Department of Planning, Industry & Environment
GPO Box 39
Sydney NSW 2001

Application No: SSD-10831778

Re: Randwick City Council submission on the State Significant Development SSD-10831778 – Sydney Children’s Hospital Stage 1 and Children’s Comprehensive Campus Centre (SSD-10831778)

1 EXISTING SHADOWS - JUNE 21 - 9AM
1:1500

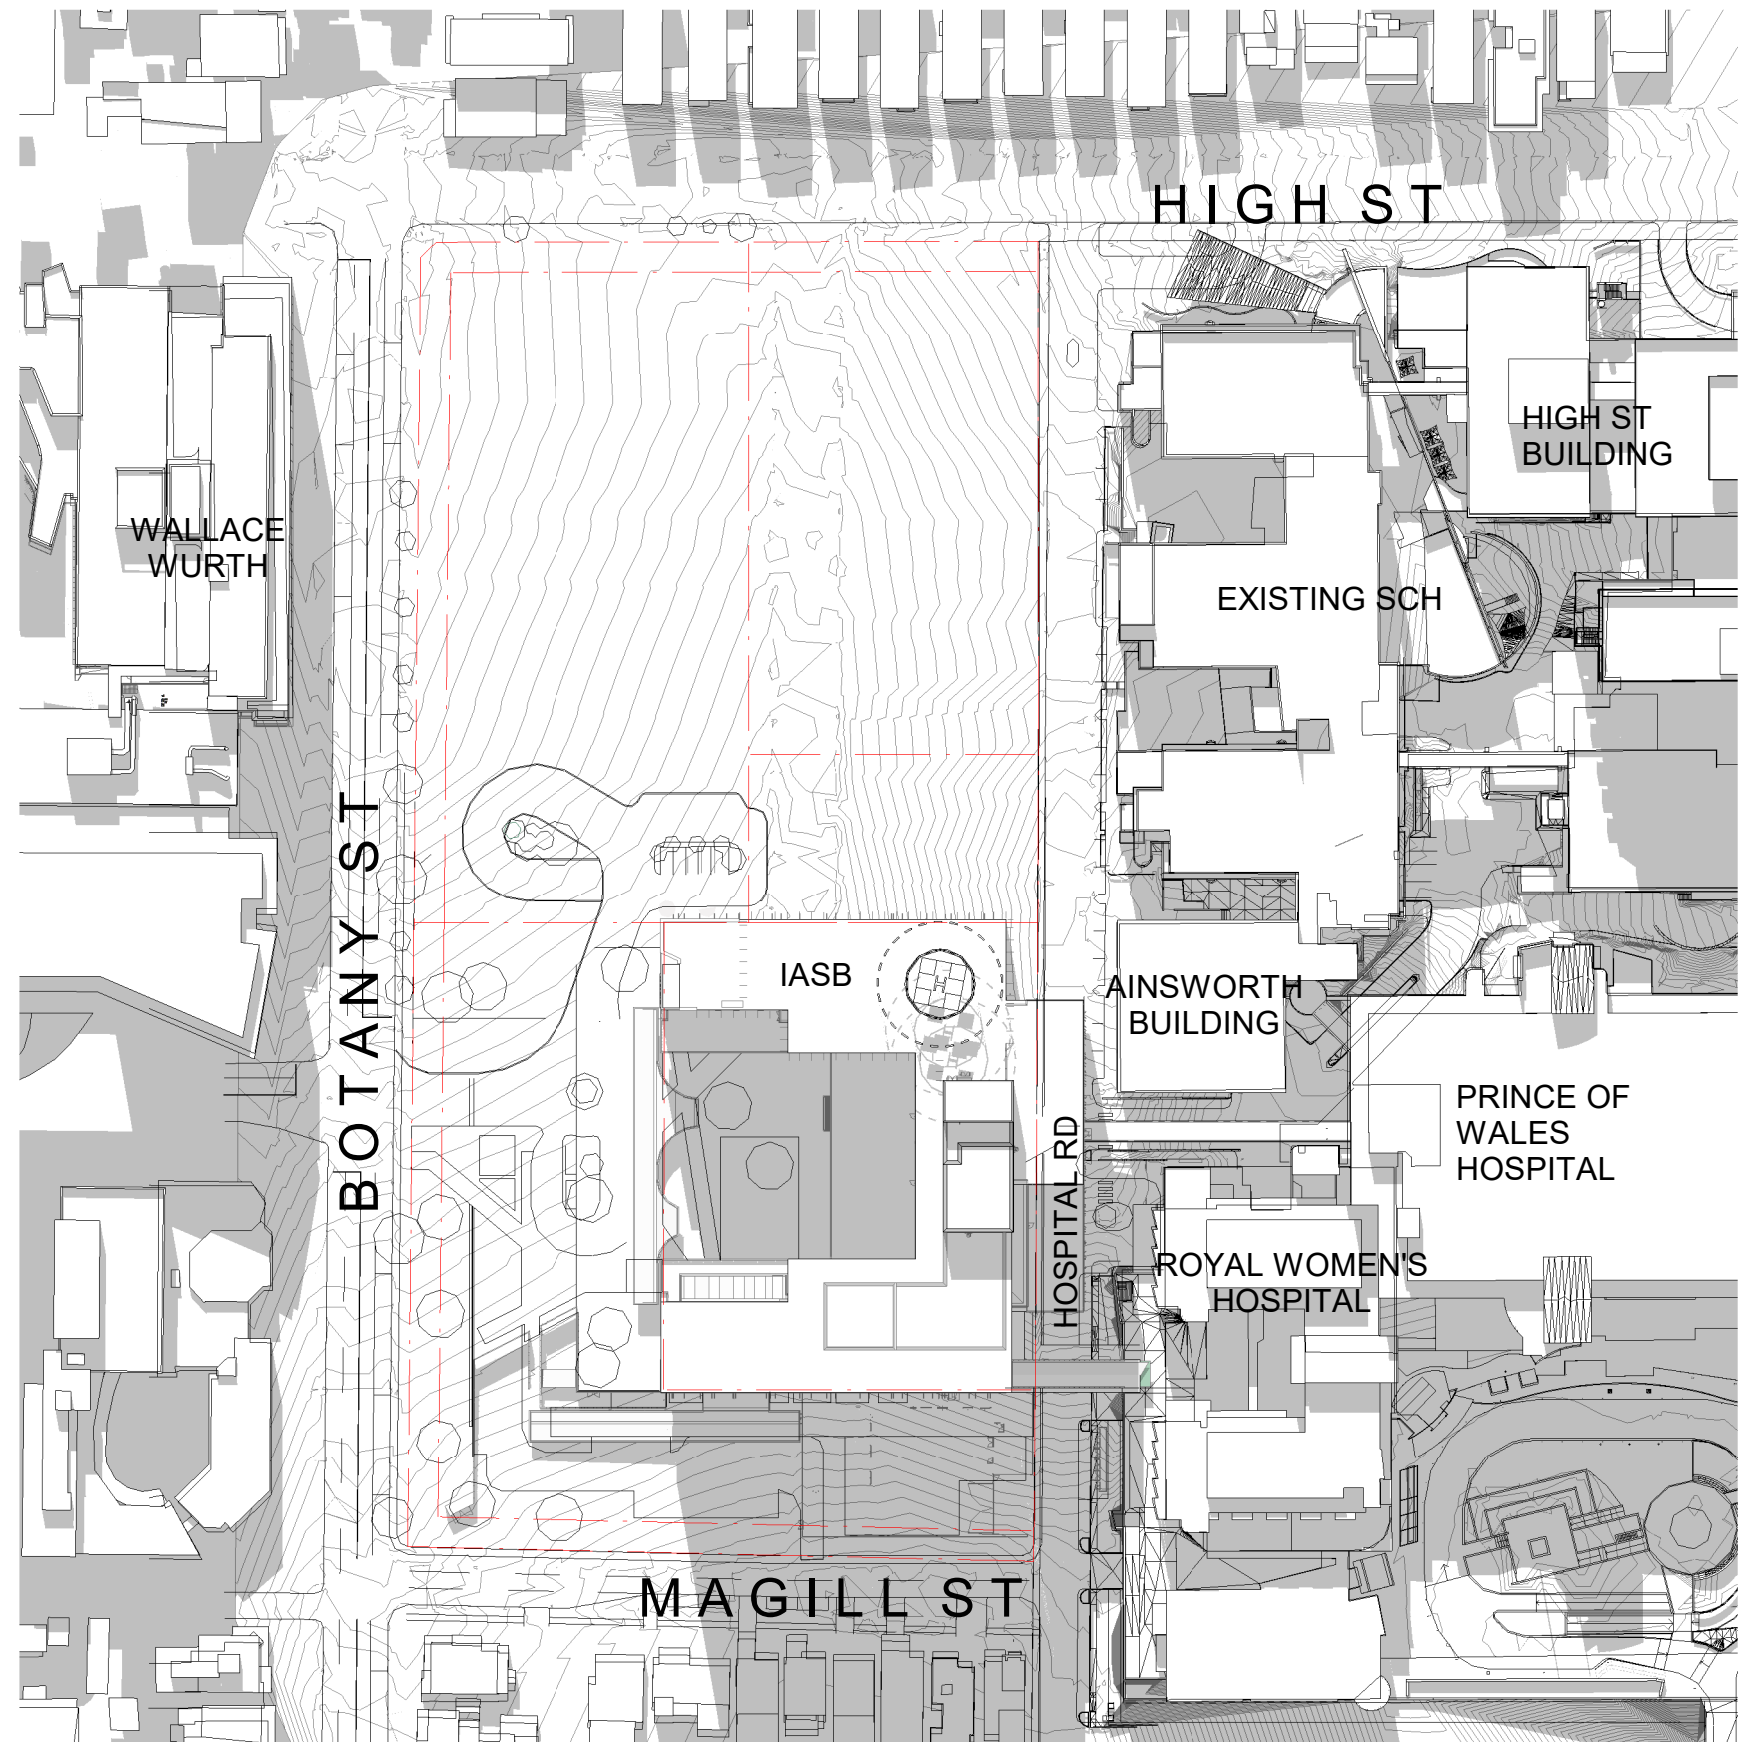
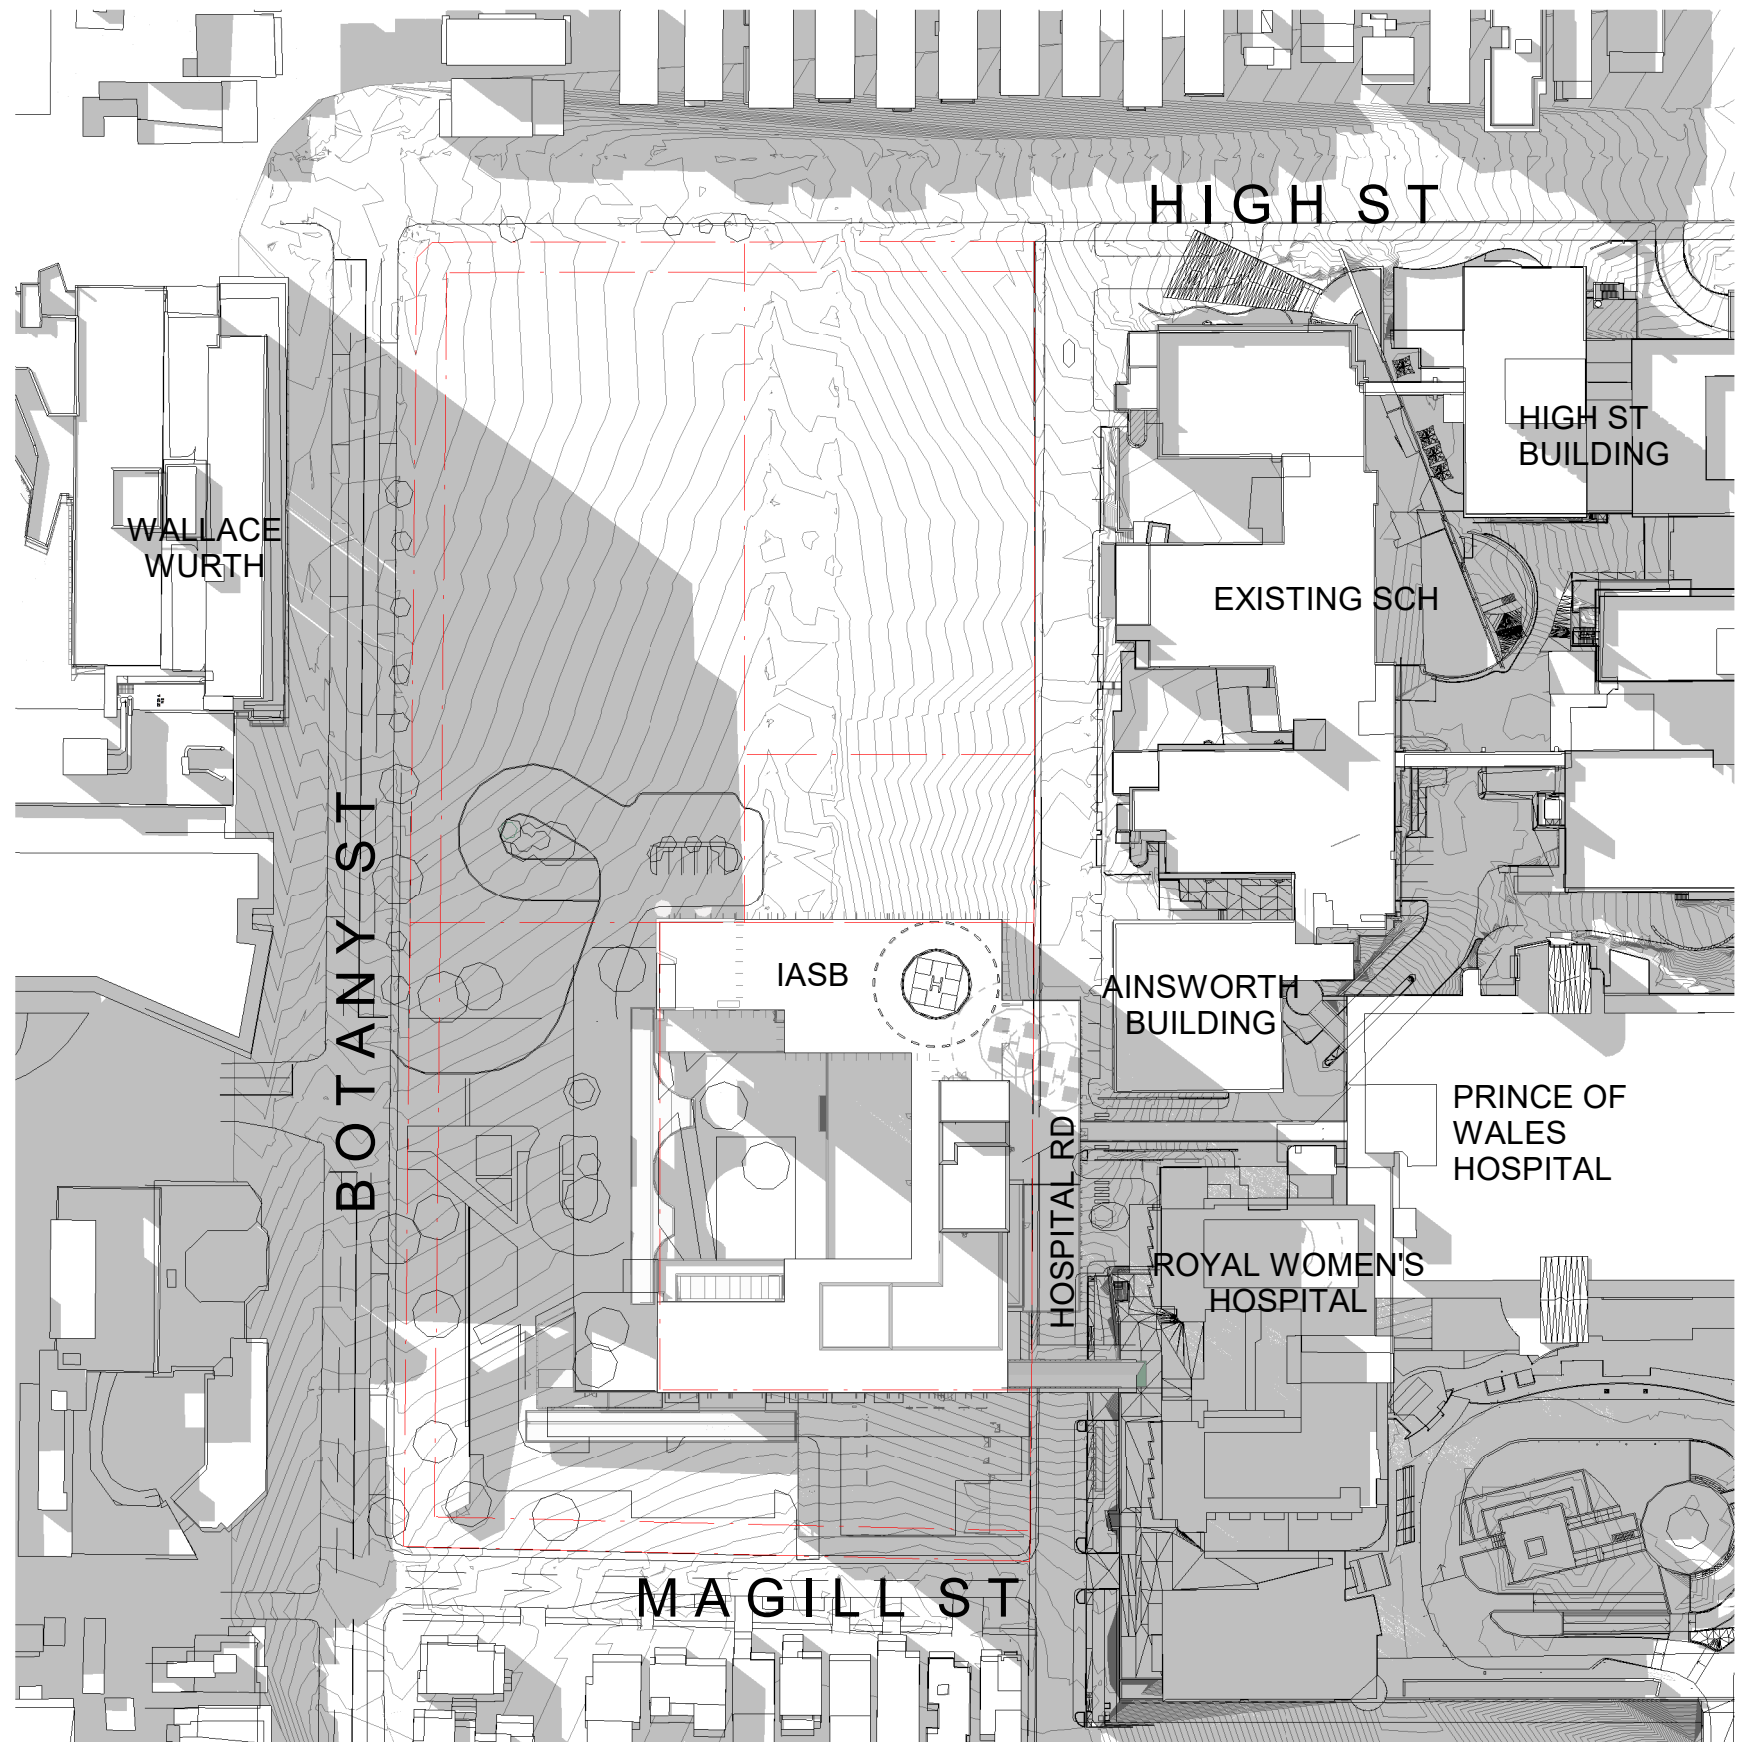
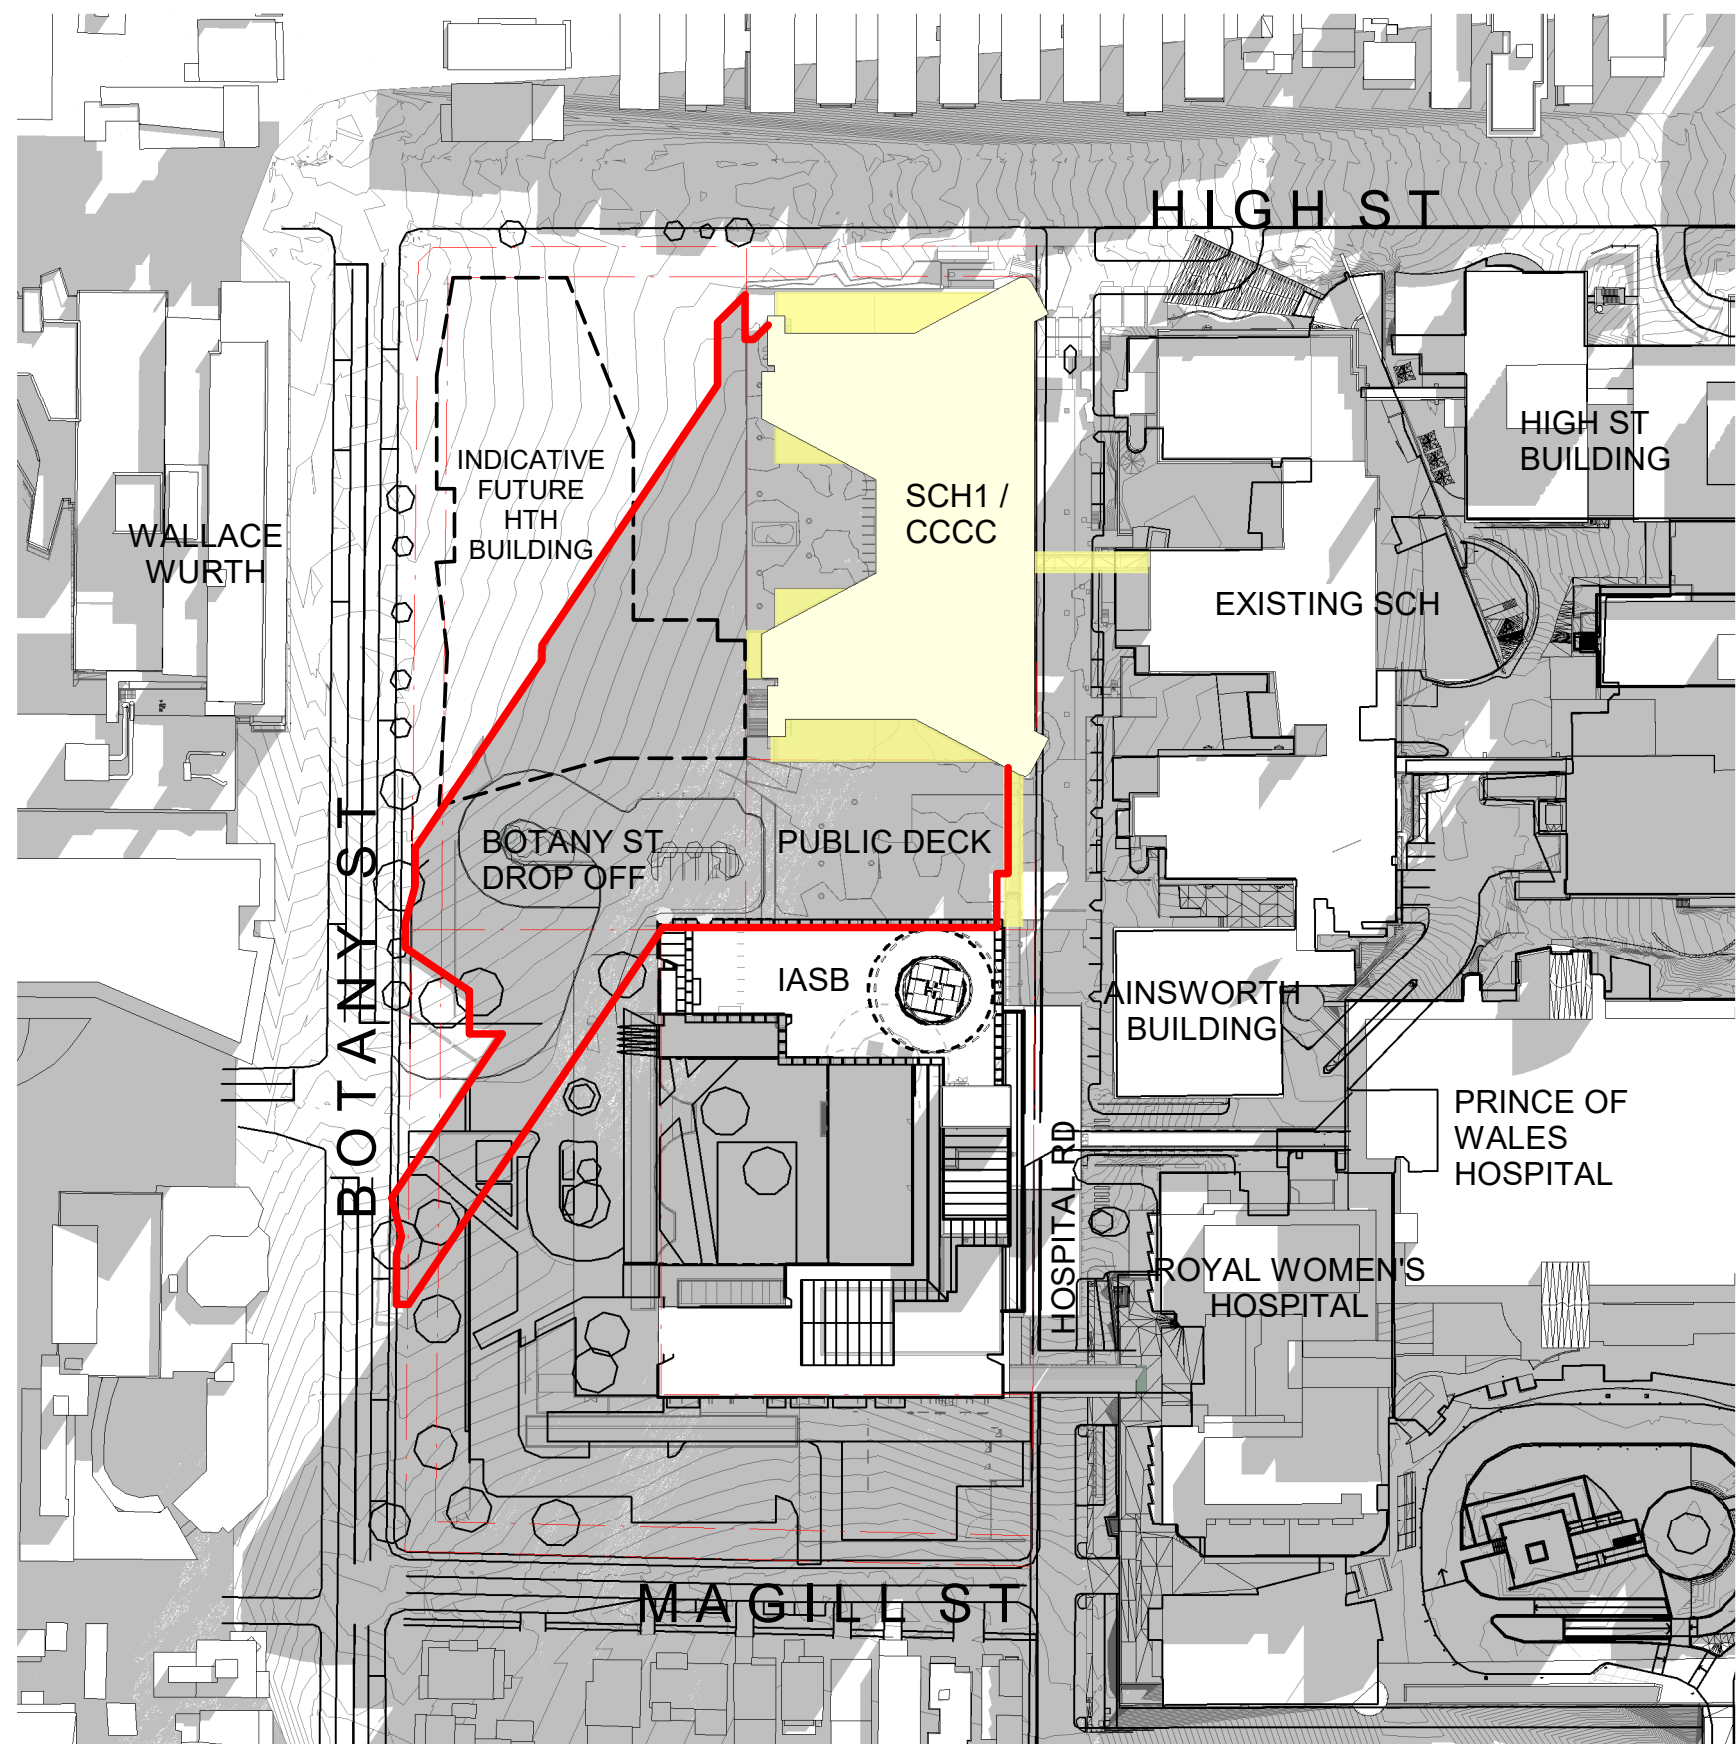
28. The proposed building will significantly overshadow the proposed children's play area through most of the year and particularly during the winter months, resulting in an inappropriate location for a children's play area. A location that receives sunshine, with a northern aspect would be preferable. Locating the play area to the north of the building, within sight of the proposed café, would provide a safer and more welcoming location. Alternatively, a north facing play area on an upper level terrace or roof of the building could be considered.

29. The north leg of the building, as proposed, blocks mid-morning sunshine from reaching the plaza. Reshaping and or increasing the height of the undercroft of the north west corner of the building should be explored to improve solar access to the plaza in the mid-morning.
